**WEST SUSSEX COUNTY COUNCIL
INFRASTRUCTURE CONSULTATION**

SUBJECT: WA/36/10

Ashurst, Binsted Lane, Binsted

Retrospective application for the retention of boundary fence and proposed replacement of main gate

ASHURST
BINSTED LANE
BINSTED BN18 0LPtitle PLANNING APP FOR WALLS /
FENCE ON BINSTED LANE

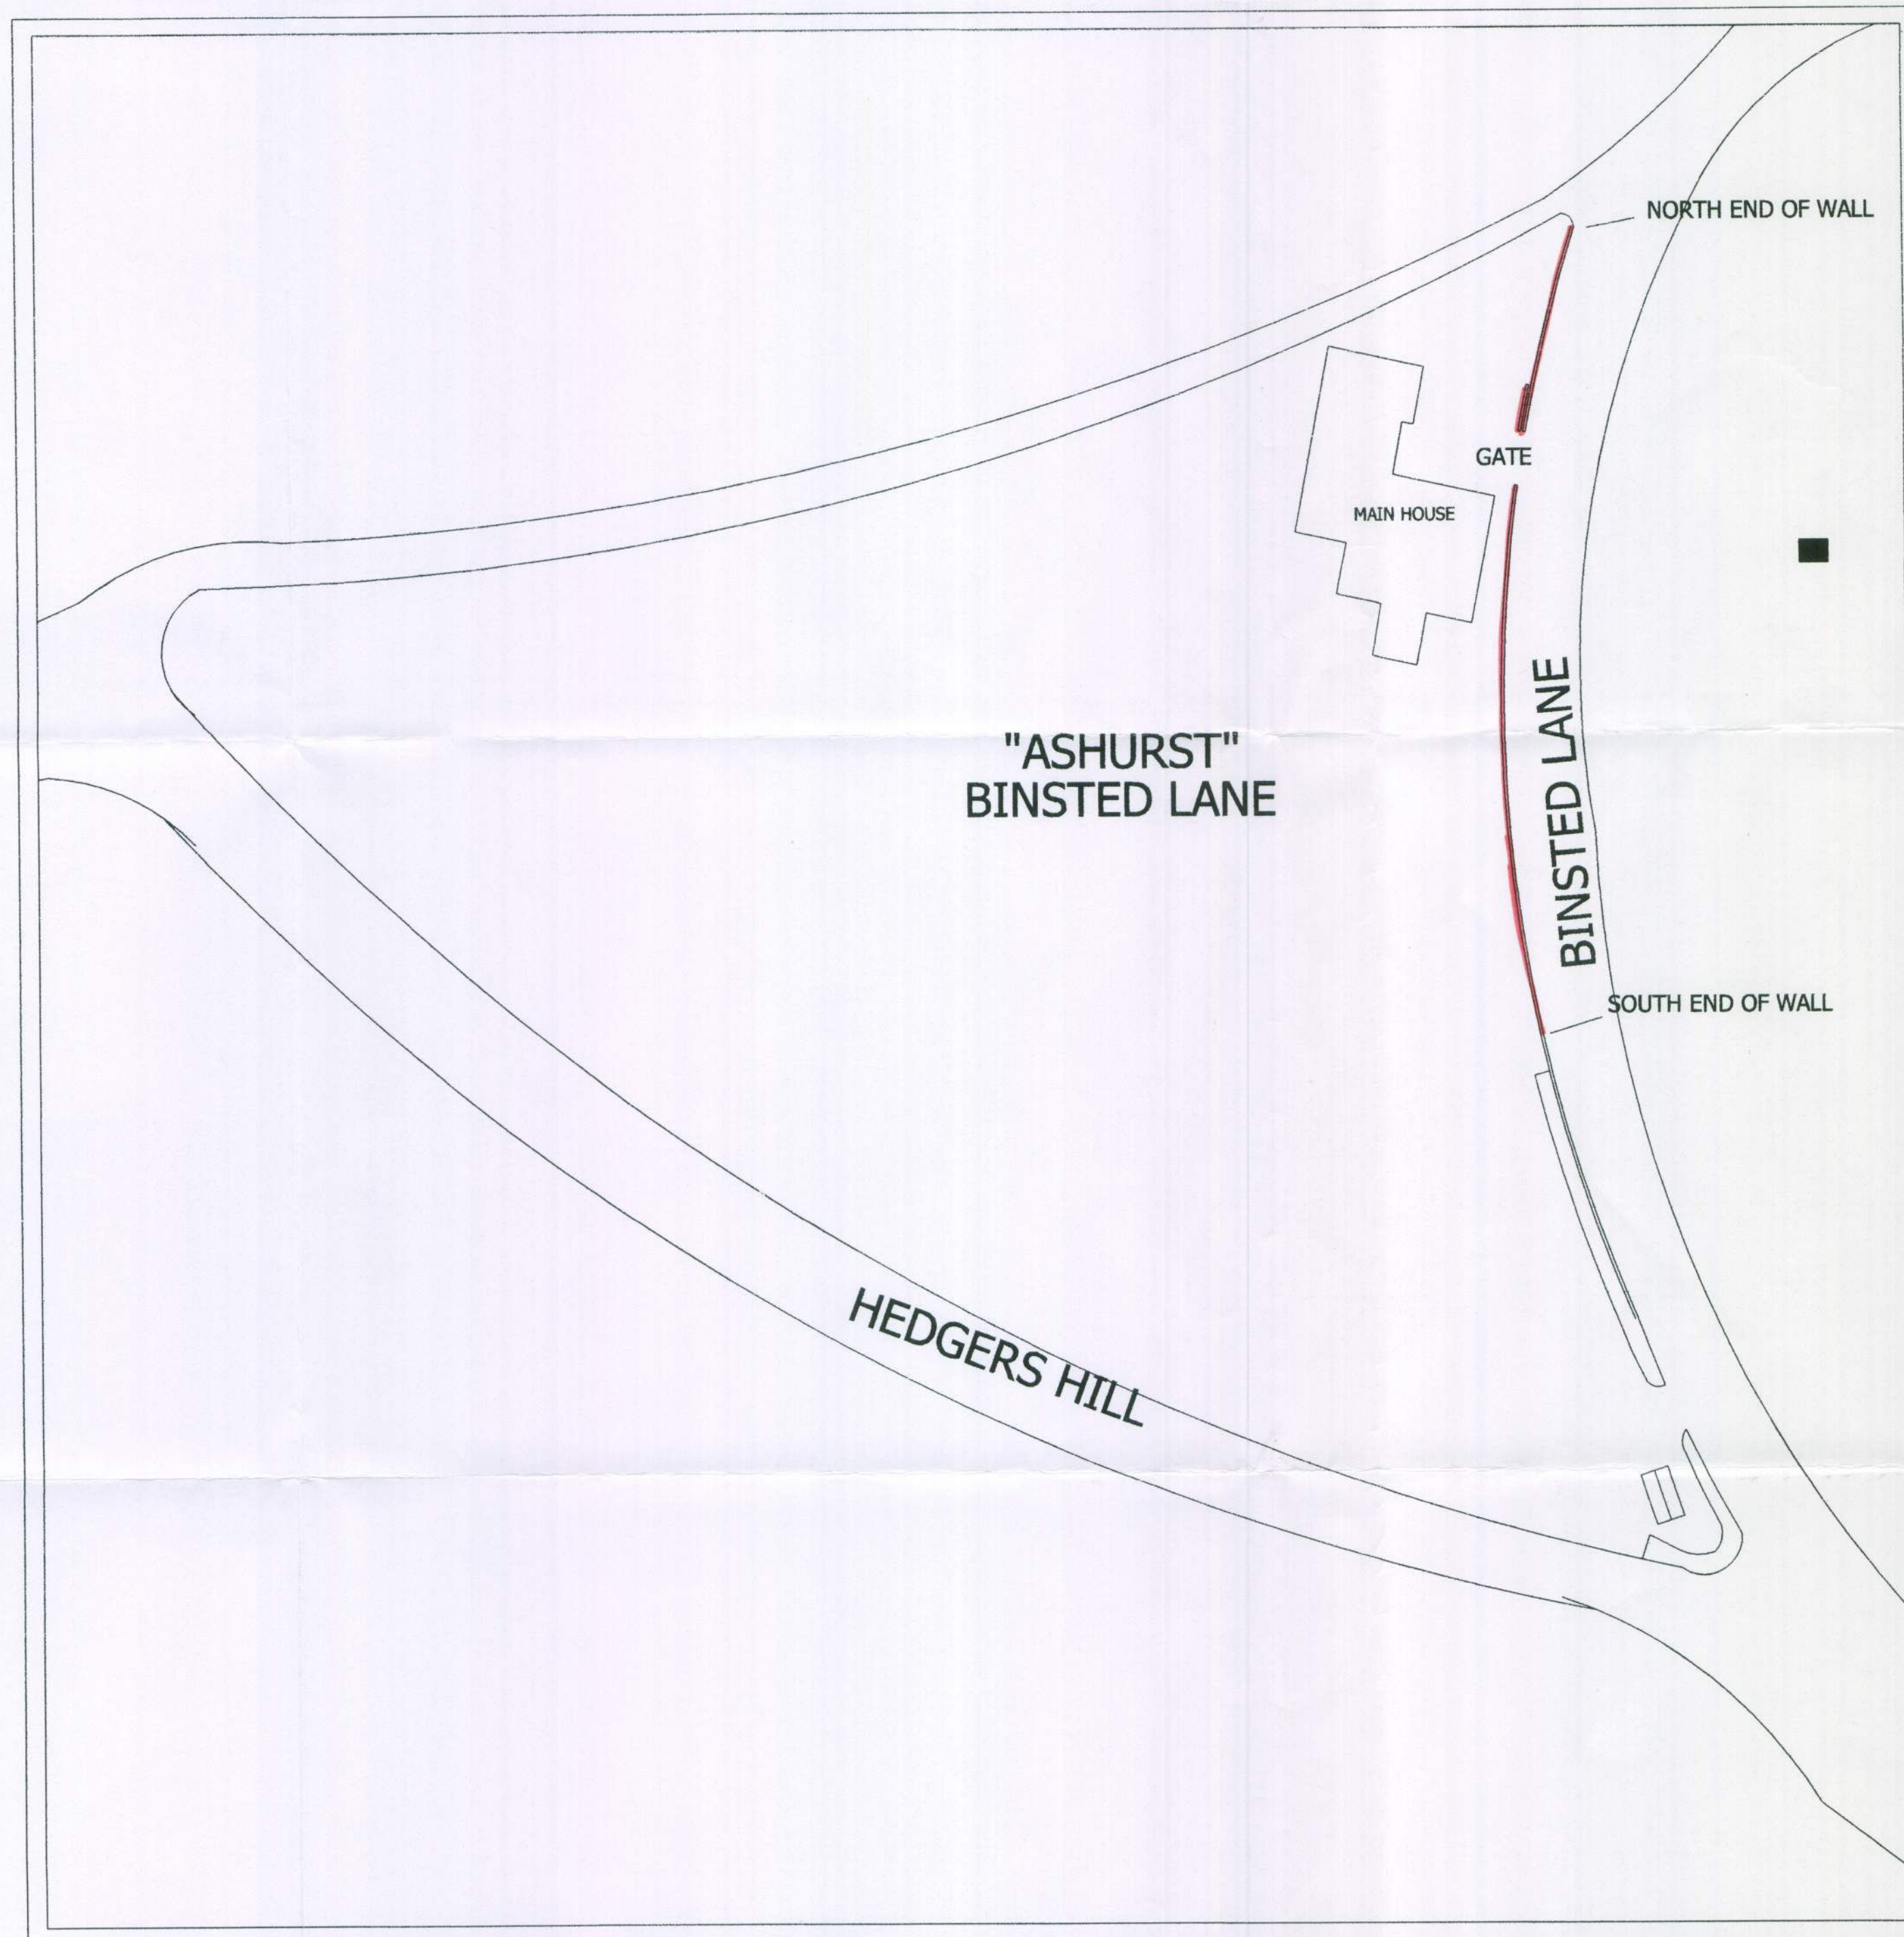
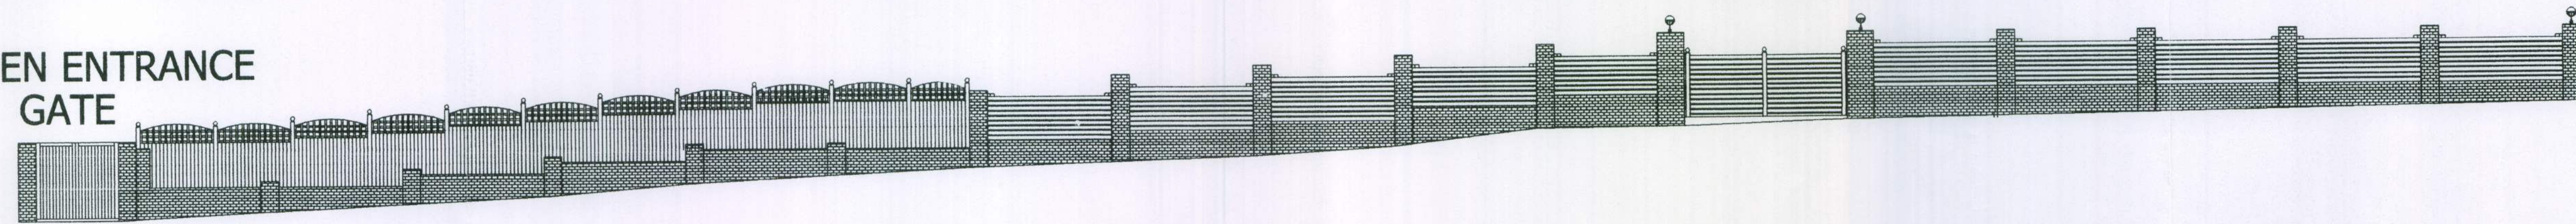
From an inspection of the plans alone, the fence does not appear to be located within the publicly maintainable highway, nor does it affect the legal line of Footpath 337 adjacent to this site. Furthermore, visibility is not compromised by the retention of this fence.

The application also concerns the 'replacement of the main gate', which would suggest that a gate has existed in this location for a period of time already, and the most recently available verified accident records reveal there have been no personal injury accidents in the vicinity of the existing point of access. WSCC would prefer any gates at the site to be located 5m back from the edge of the carriageway of Binsted Lane.
